## Portland Water District

April 8, 2019

Re: 145\_165 Presumpscot Street, PO  
Ability to Serve with PWD Water - **REVISED**

DRAWING NO.
C-20

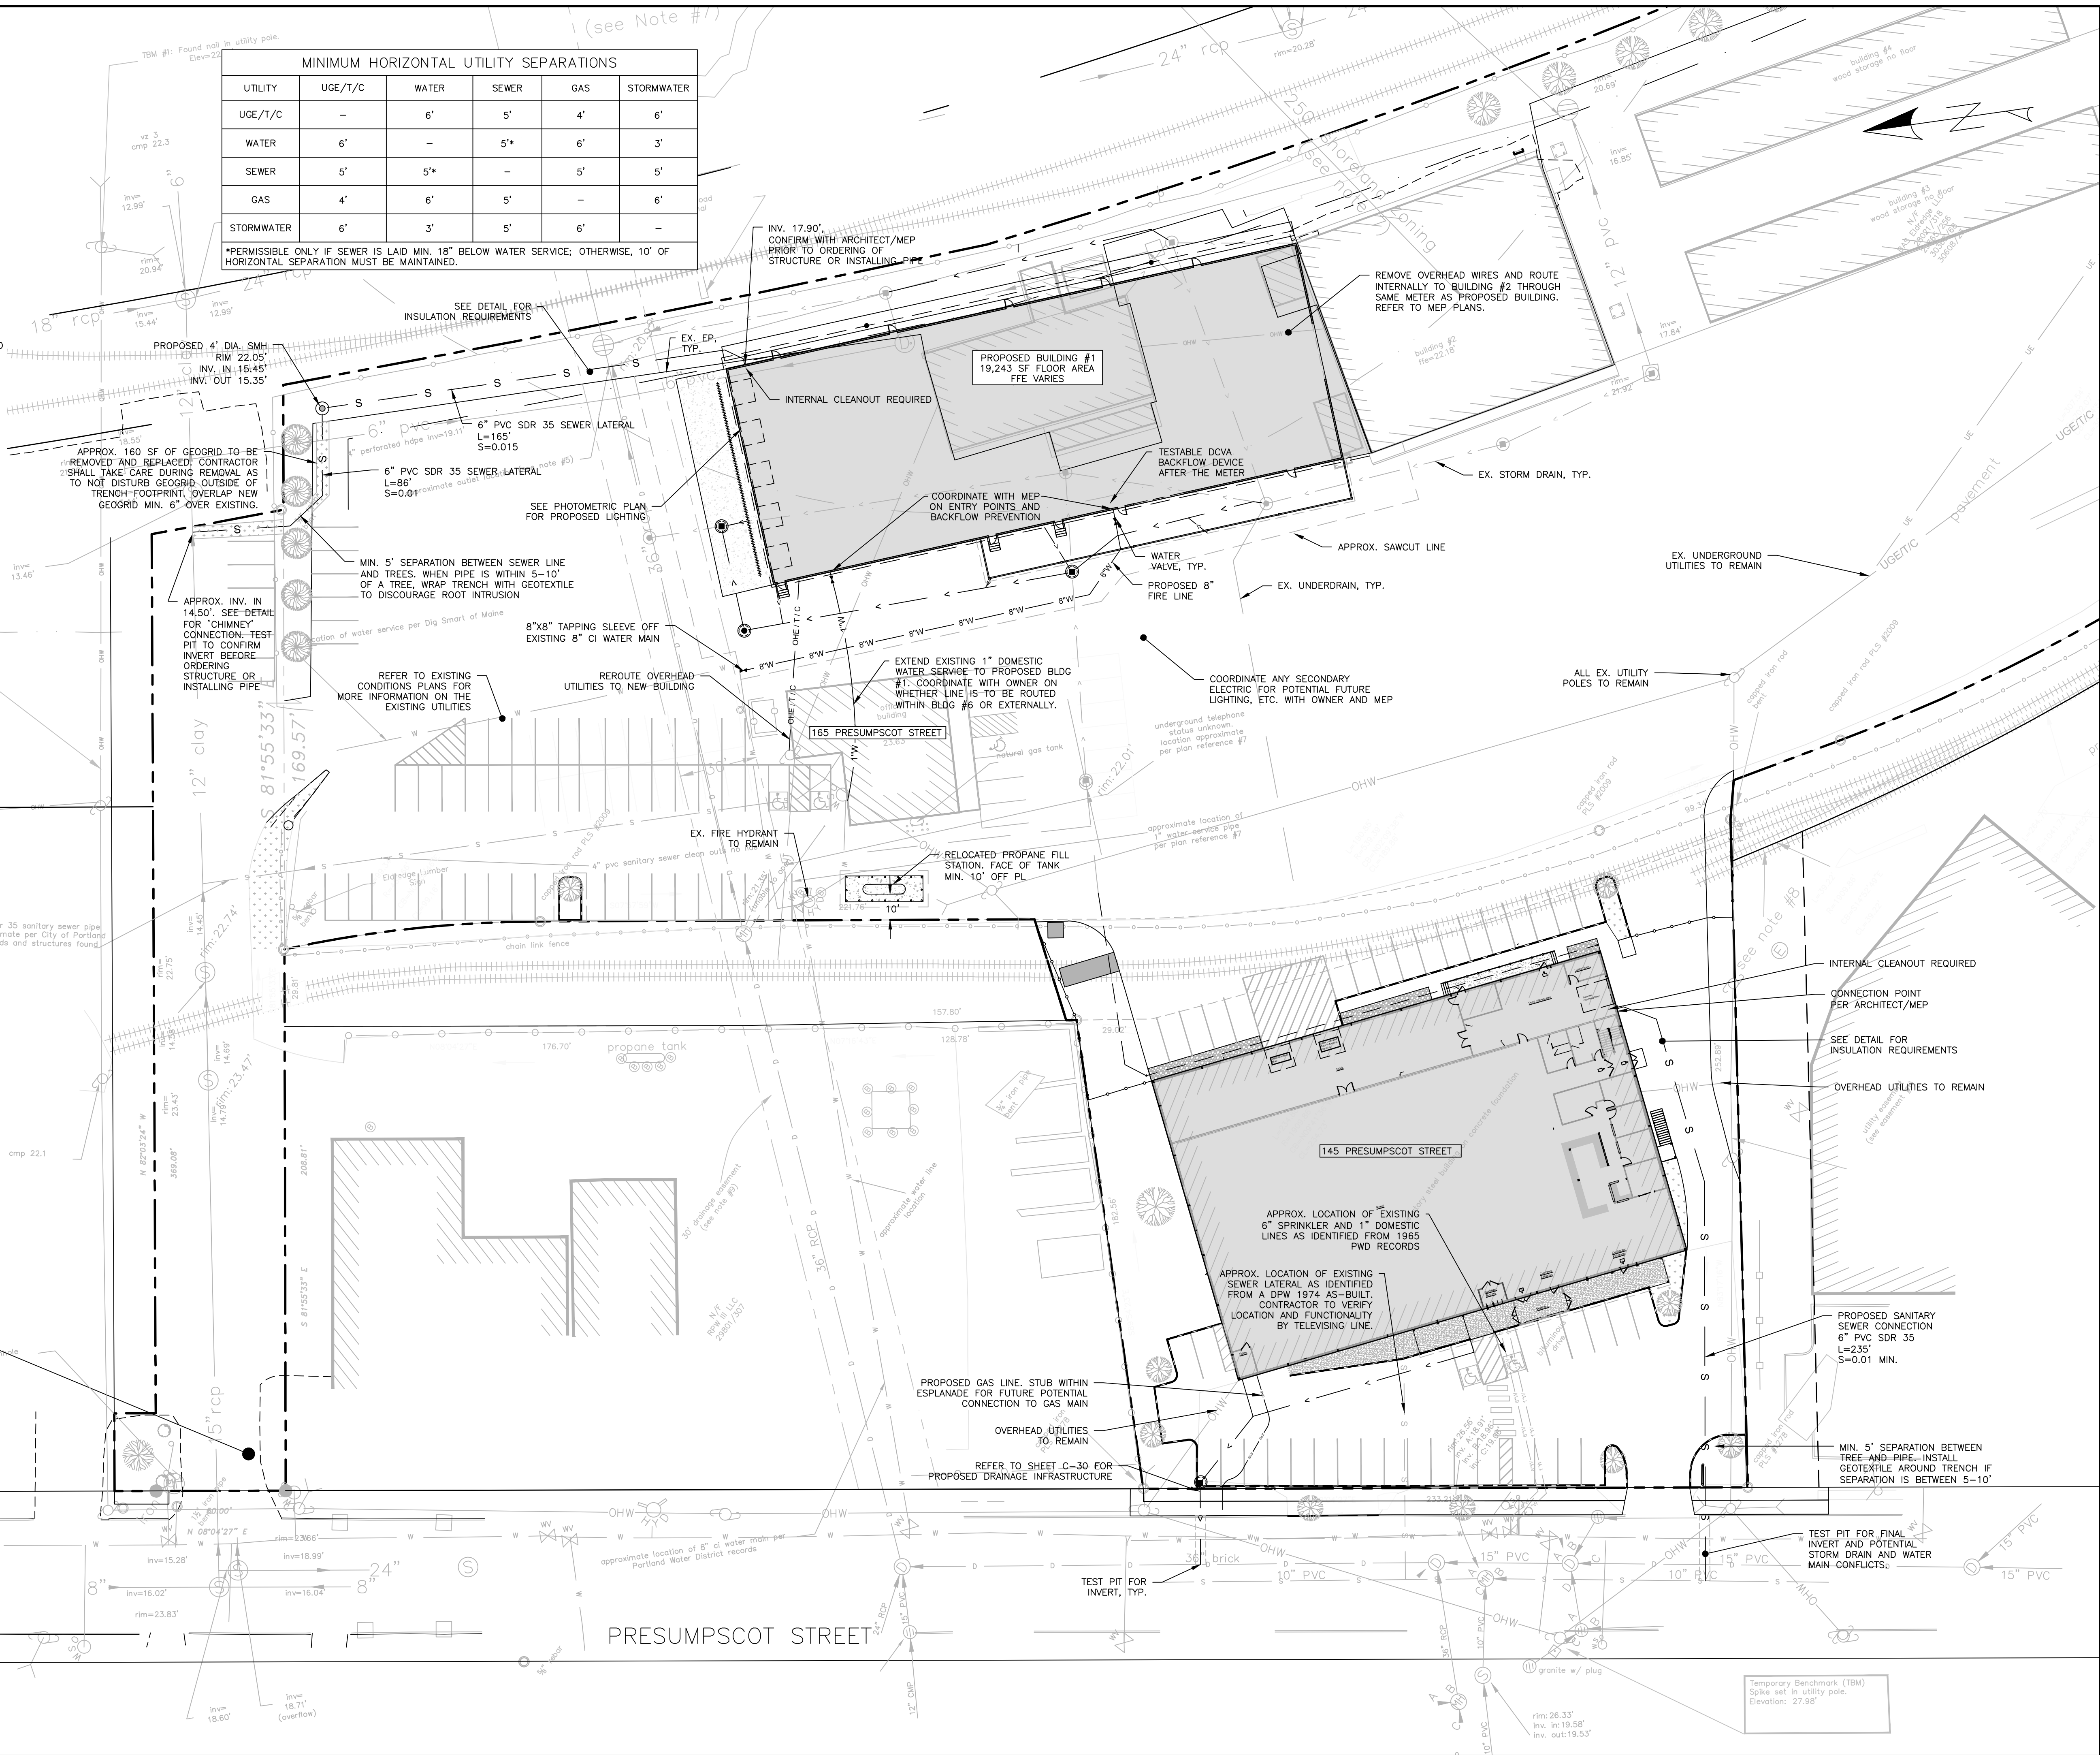
- The existing service lines at 145 and 165 Presumpscot Street may be used to provide fire and domestic water service to the buildings as long as the project team determines that they will provide adequate flow and pressure for the proposed use. The domestic water service connection from the Office to Building #1 at 165 Presumpscot Street must be made after the meter and backflow prevention device.
- An approved backflow prevention device must be installed on the domestic service line directly after the meter at 145 and 165 Presumpscot Street. Please refer to the PWD website for more information on cross-connection control policies.

According to District records, the project site does currently have existing water service. At 145 Presumpscot Street, a 6-inch diameter cast iron service line provides fire service to the site and a 1-inch copper water service line provides domestic water service to the site; at 165 Presumpscot Street an 8-inch diameter cast iron service line provides fire service to the site and a 1-inch service line is connected on private to supply domestic water service to the small office building. Please refer to the "Conditions of Service" section of this letter for requirements related to the use of this service.
